Planning Application Ref: AW/108/14/T

Location : 233 Manor Way, Aldwick Bay Estate, Bognor Regis

Description of works: Fell 1 x Eucalyptus tree

Location of
Eucalyptus tree.

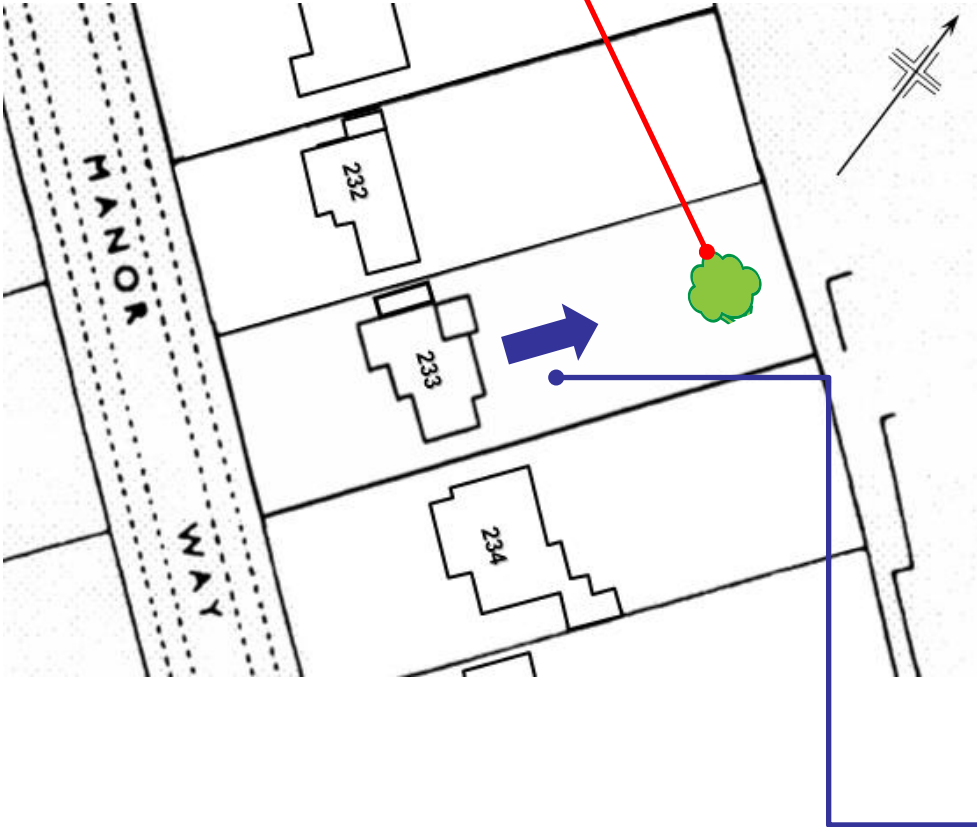
- This tree is a significant distance from the rear building line of the property and does not pose a risk to same
- However, I have looked at this tree before and refused pruning and recommended that they consider removal instead and at that time the tree was in good health – it has now suffered significant foliage dieback from the past Winters storms and is in a poor state.
- I would have no objection to its removal but would wish to see a replacement tree at this location.

I **Approve** of the works as described in the application documents subject to a replacement tree being planted at the same location - to be a Standard Nursery Stock size of tree 8 -10 feet tall and 8 to 10cm circumference and of one of the following species:-
